From: James Cross <James.Cross@arun.gov.uk>
Sent: 17 December 2019 12:39
To: Planning.Responses <Planning.Responses@arun.gov.uk>
Subject: FW: BR/62/11 - Rear of 2 Cavendish Road, Bognor Regis, PO21 2JW

Proposed Ground Floor Plan

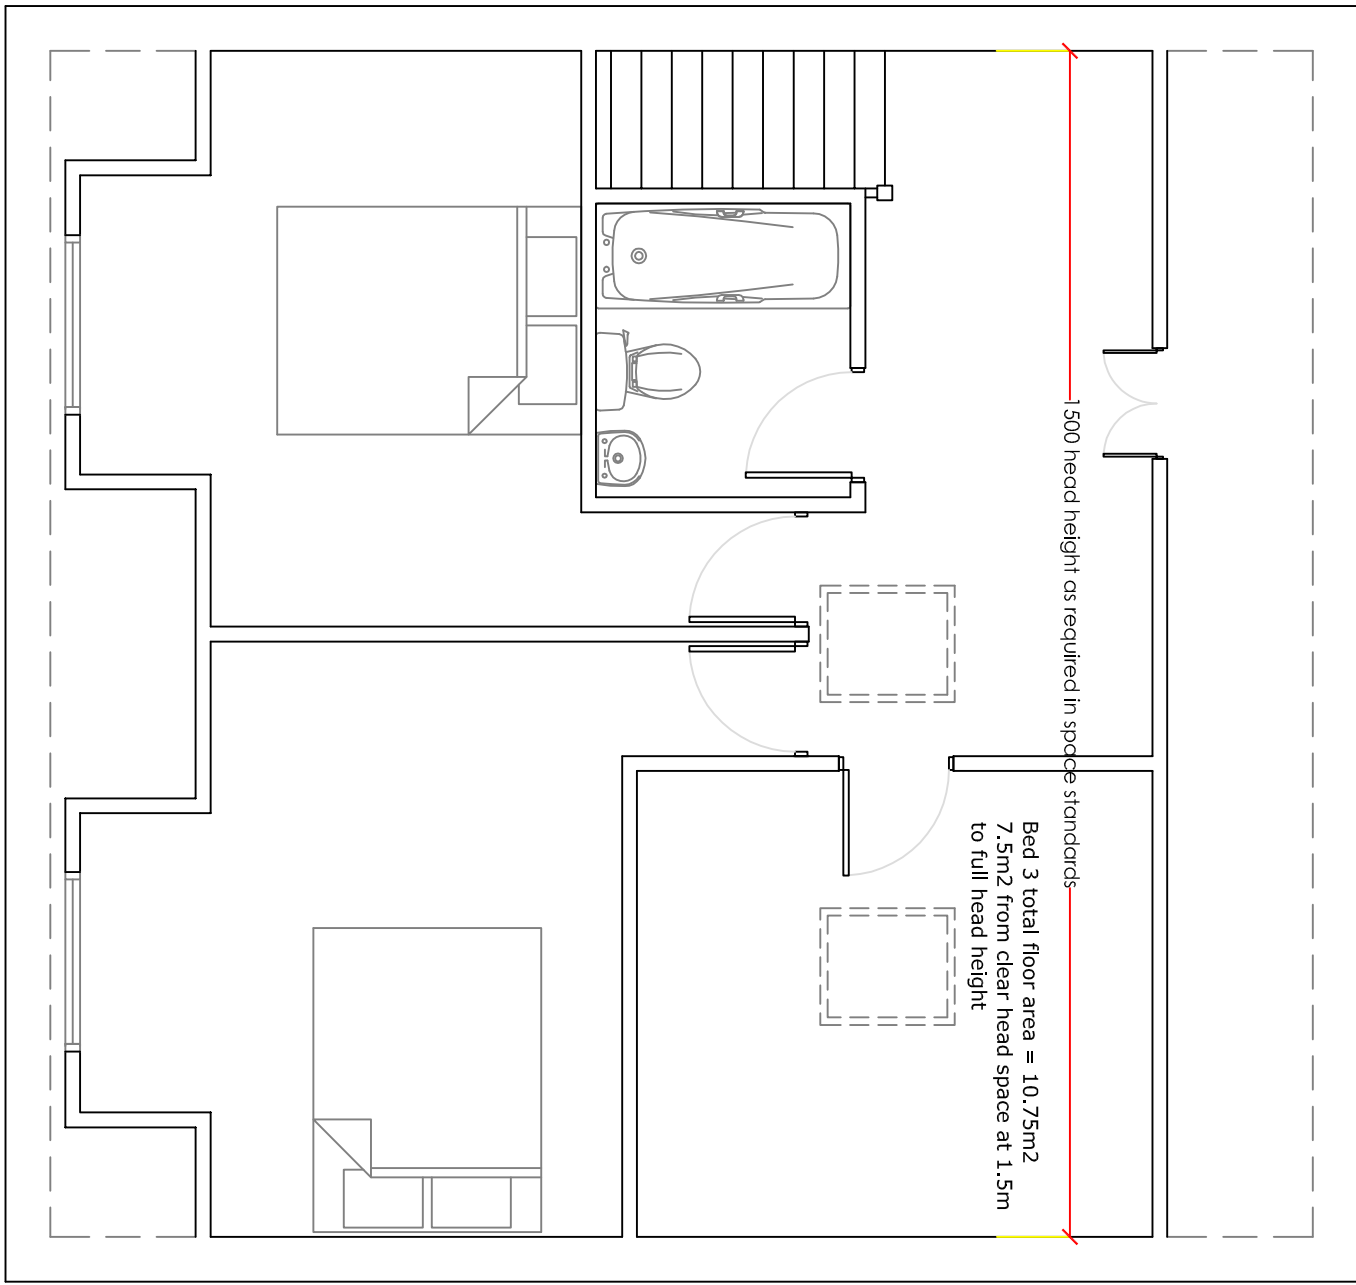
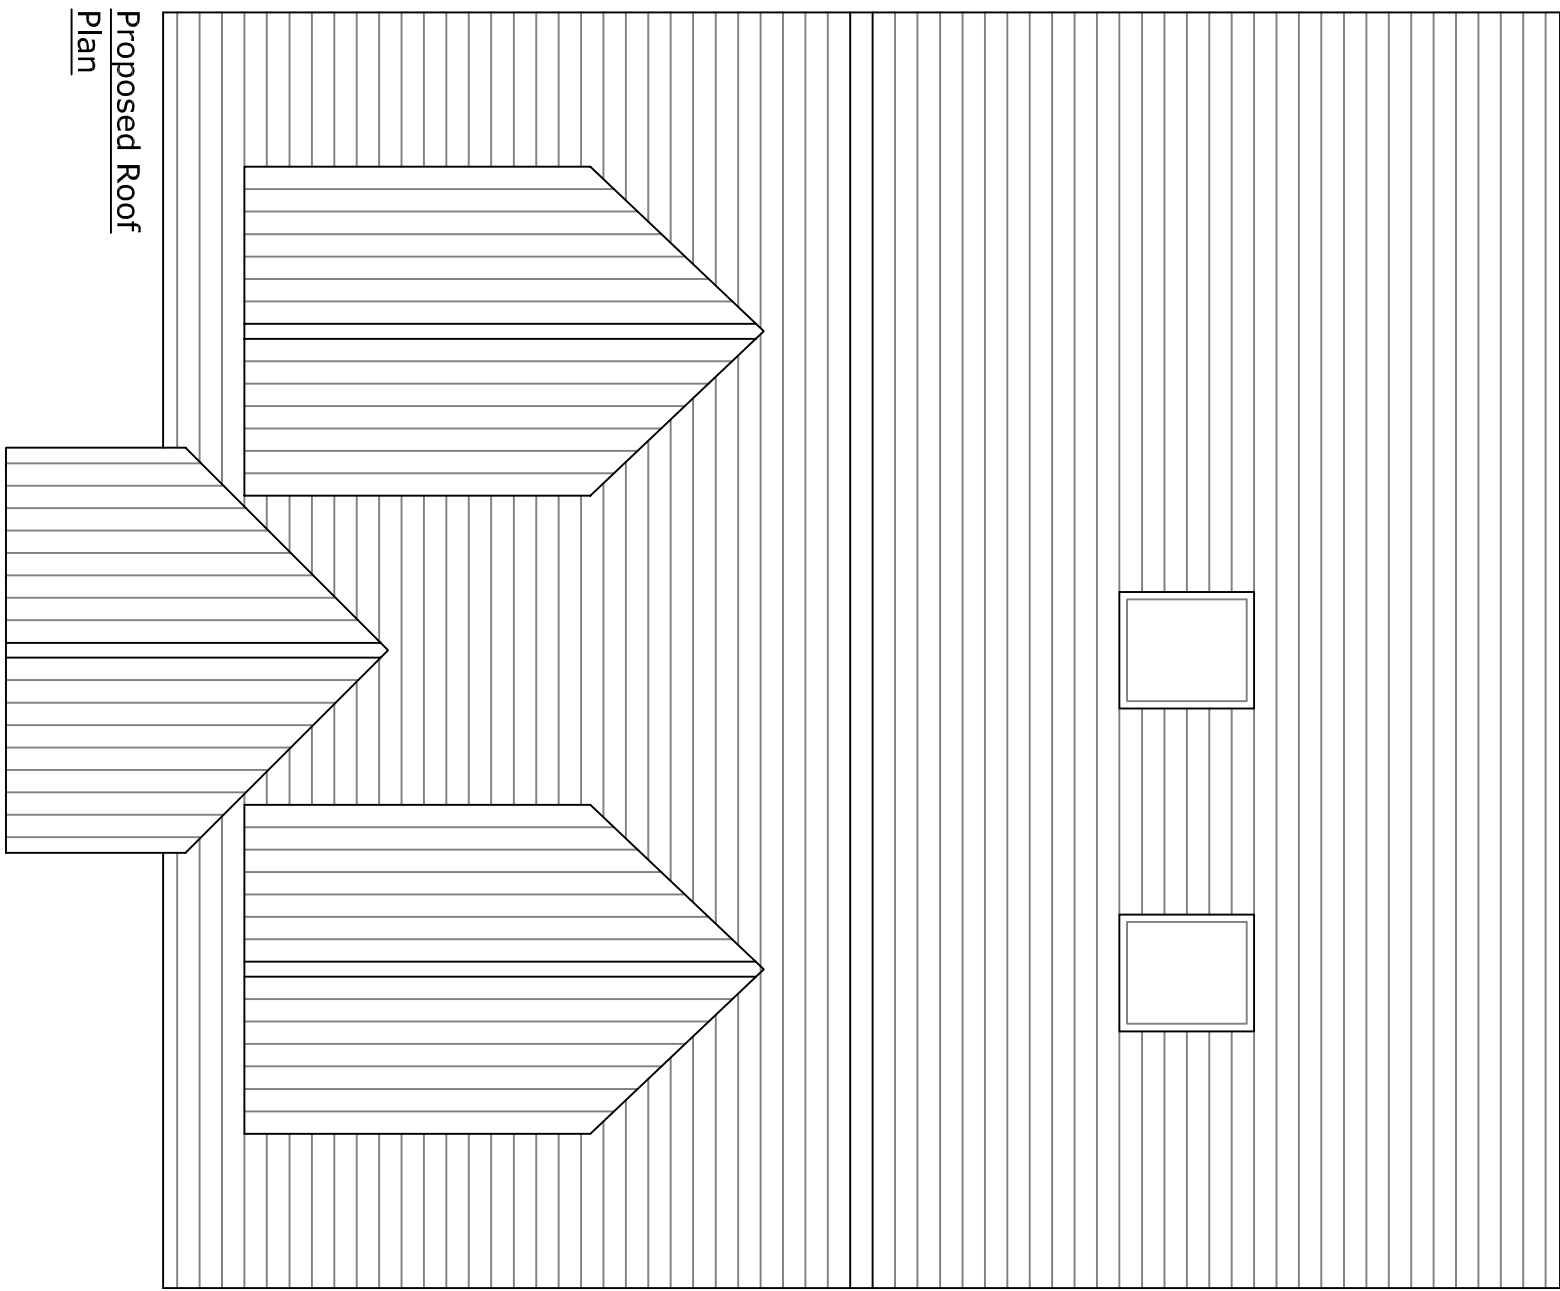
I also note that the empty bedroom is still shown on the plans and annotations refer to 'Bedroom 3'. Can you please show this as a study or reconfigure the internal layout to accord with the 2 bedroom layout. All submitted plans need to accord with the description of development.
